# A303 Sparkford to Ilchester Dualling Scheme TR010036

## 8.3 Draft Statement of Common Ground with Historic England

**DRAFT STATEMENT OF COMMON GROUND**

**This Statement of Common Ground has been prepared and agreed by (1) Highways England Company Limited and (2) The Historic Buildings and Monuments Commission for England (HBMCE).**

A303 SPARKFORD TO ILCHESTER DUALLING
WORKS PLANS REGULATION 5(2)(J)
SHEET 3 OF 4

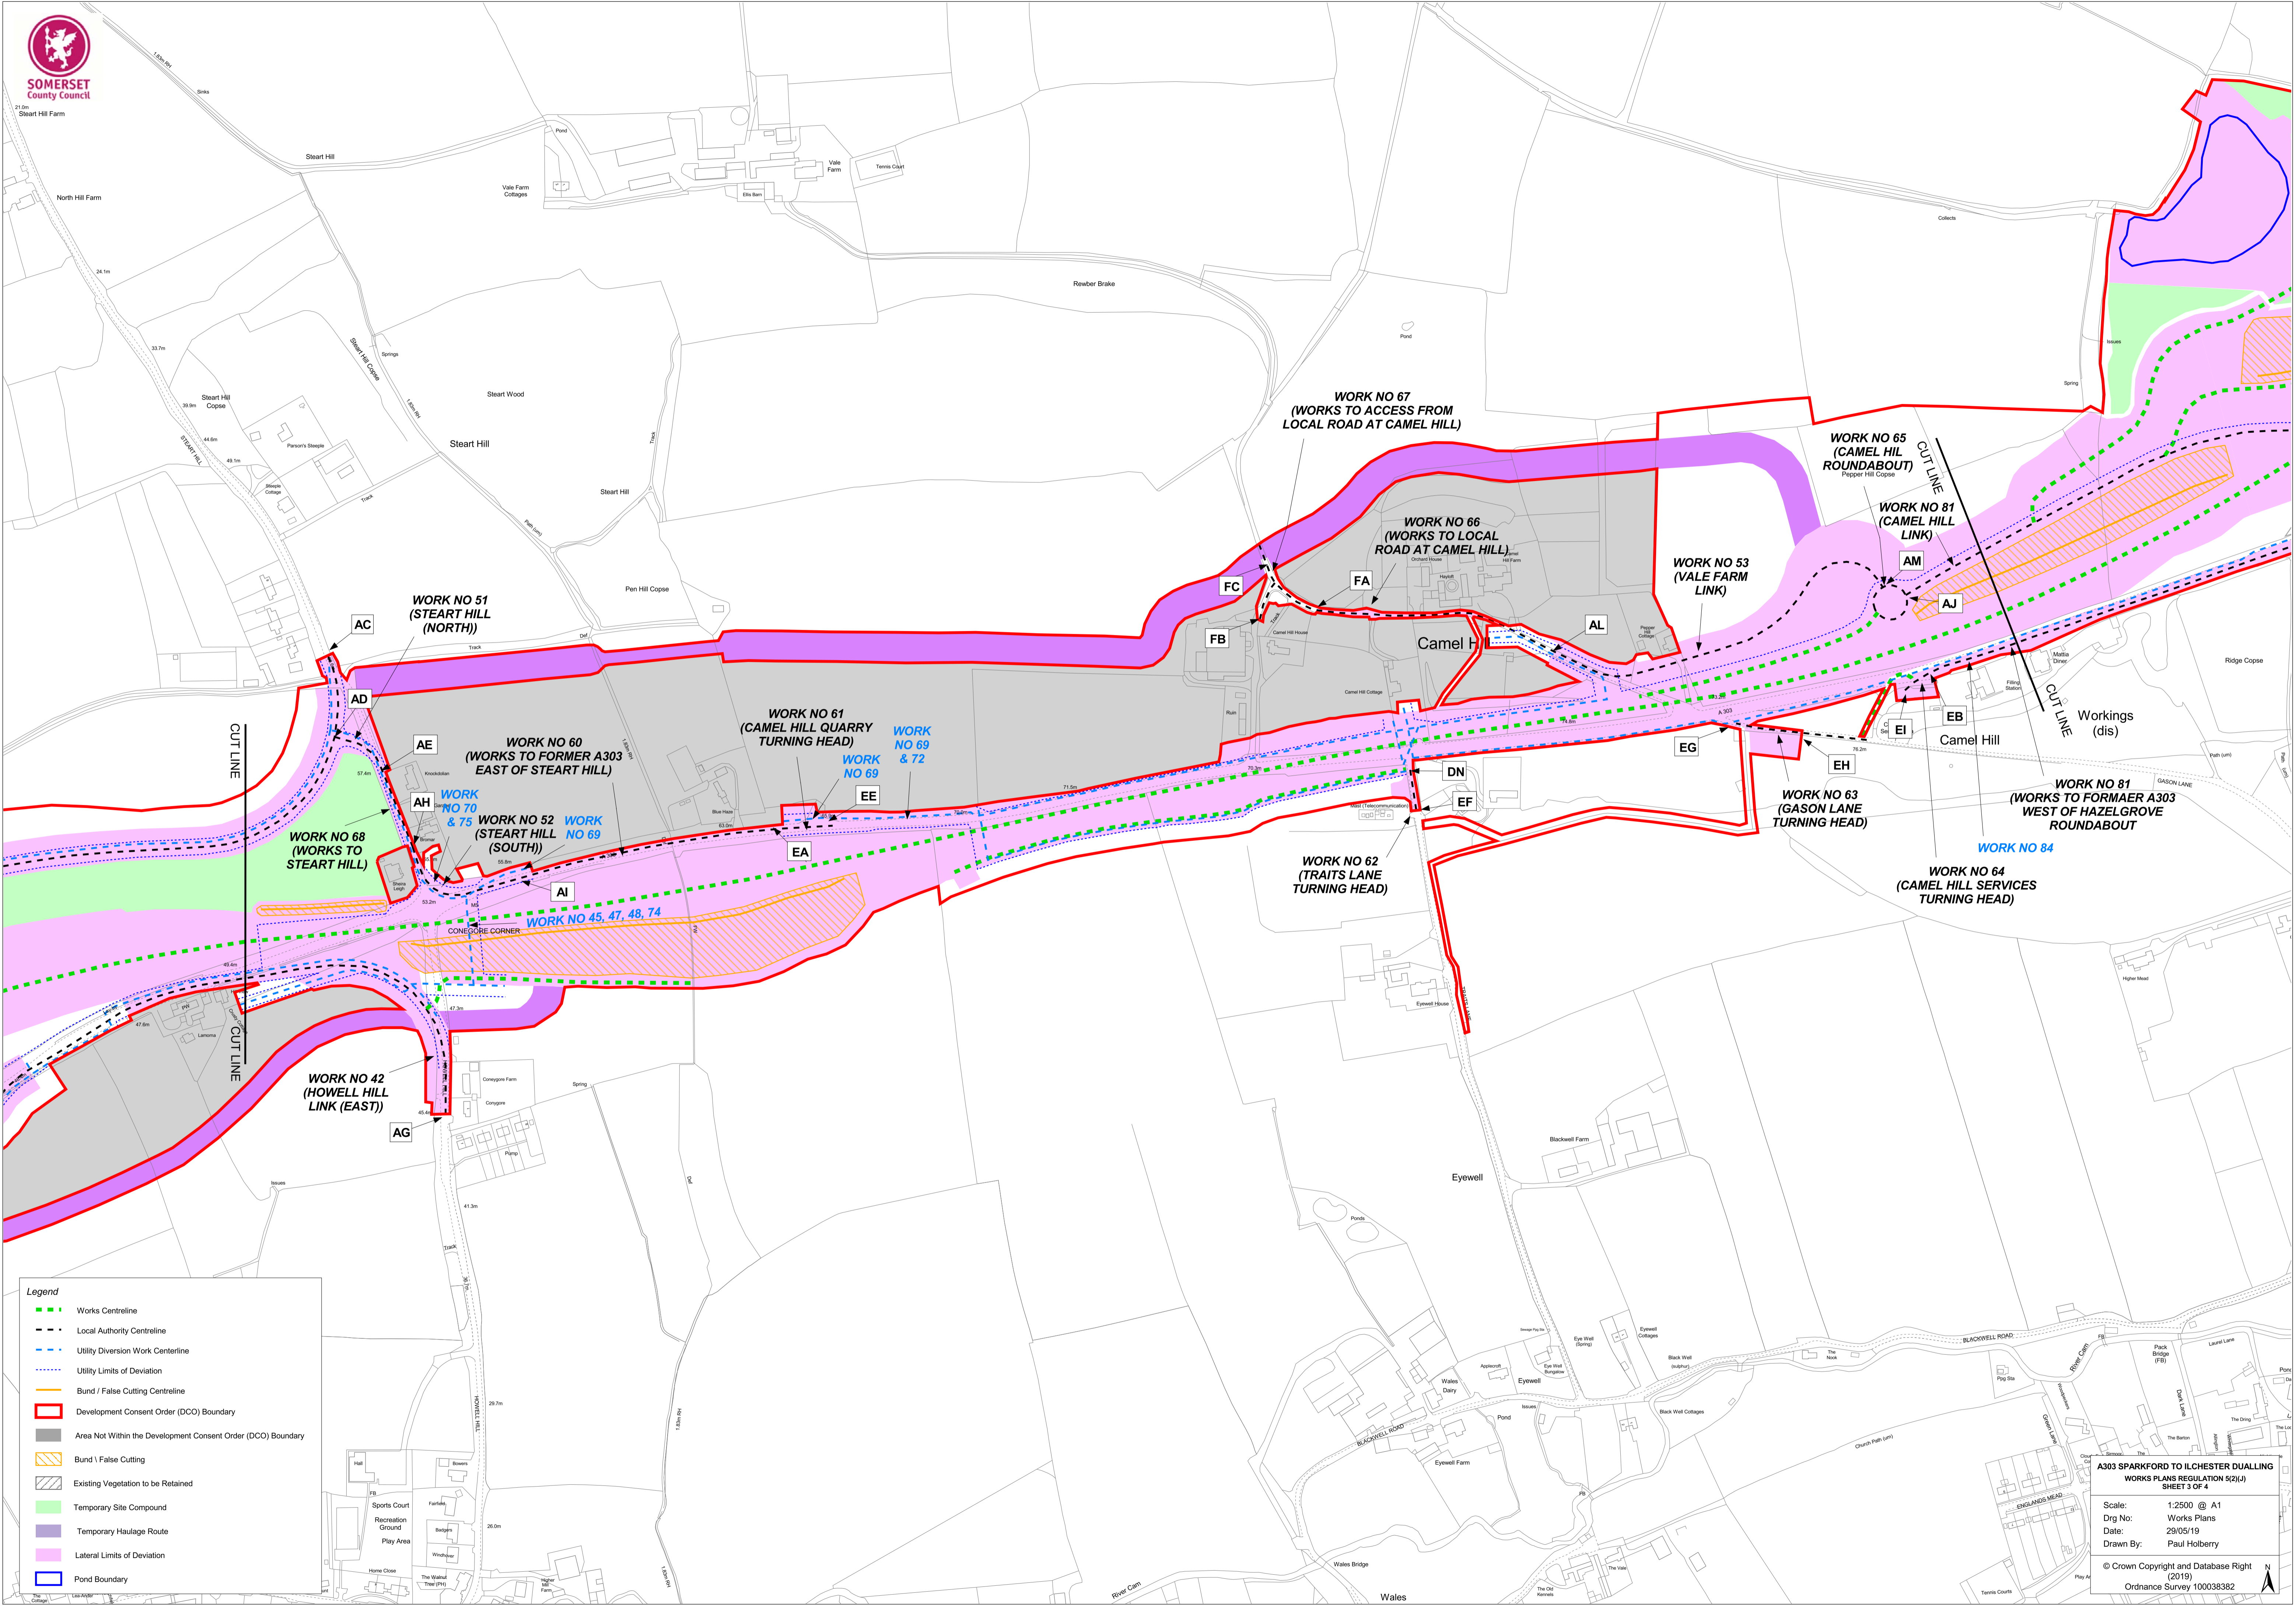
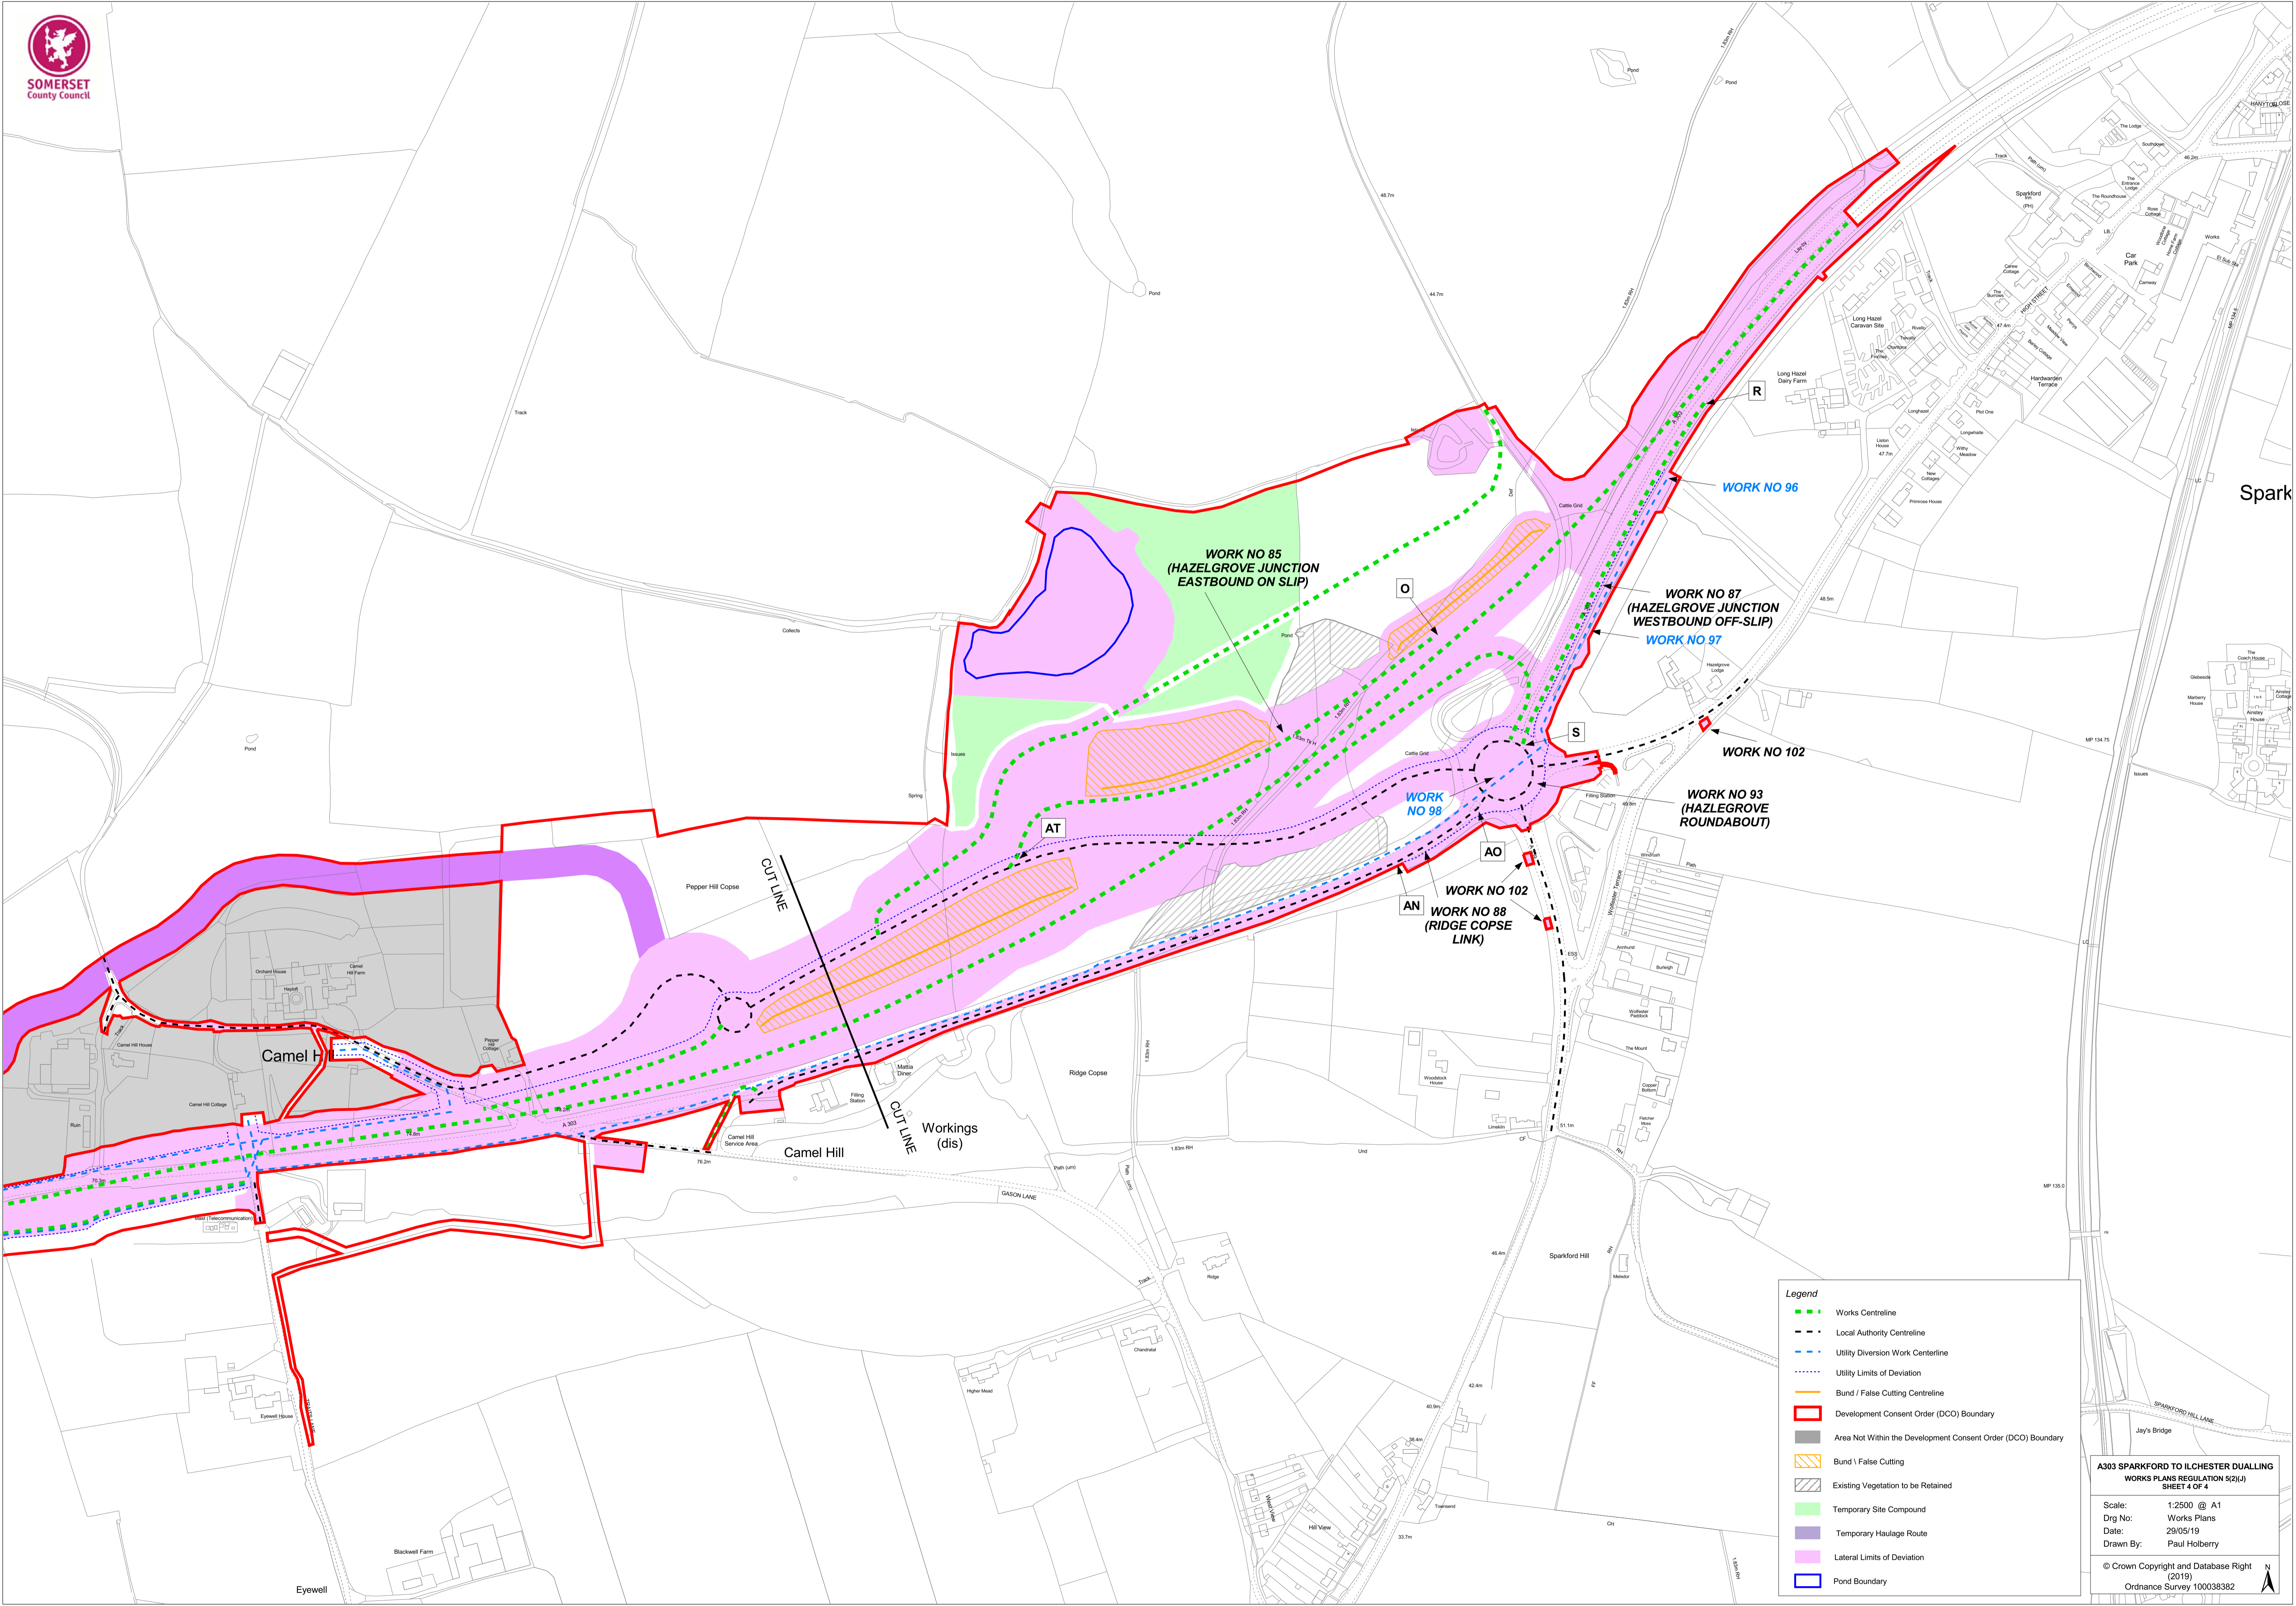
Topic	Sub-section	Historic England comment	Highways England response	Status
		<p>HBMCE would welcome confirmation from the Applicant that the limit of lateral deviation included on the Works Plans (Sheet 3 of 4) will not entail encroachment within the Camel Hill scheduled monument.</p>	<p>The lateral limits of deviation are restricted by the red line boundary (RLB). At its closest point which is the south-west corner the RLB is 1.5 metres from the monument. The southern boundary of the monument it is between 10 metres and 15 metres from the RLB.</p> <p>A works plan showing the scheduled monument and the limits of deviation is being prepared to be shared with HBMCE at Deadline 4.</p>	<p><b><i>UNDER DISCUSSION</i></b></p>
		<p>The location of the haul route to the north of the SM has the potential to remove or compact remains associated with the monument.</p>	<p>Geophysics and a trench evaluation have been carried out within the footprint of the temporary haul route to establish the potential for archaeological remains. The results of the geophysics surveys and archaeological trial trenching were submitted as part of the Examination on 23 January 2019 (REP2-005) and have been shared with HBMCE. Any archaeological mitigation will be based on the findings of this evaluation and has been included in the OHWSI to be submitted to the examination. A draft of the OHWSI will be shared with HBMCE, SSDC, and SCC for comment prior to submission.</p> <p>The haul route around Camel Hill SM would be raised by the installation of geotextile membrane prior to the placement of temporary granular infill. This would be over the existing ground and would not require vegetation</p>	<p><b><i>UNDER DISCUSSION</i></b></p>
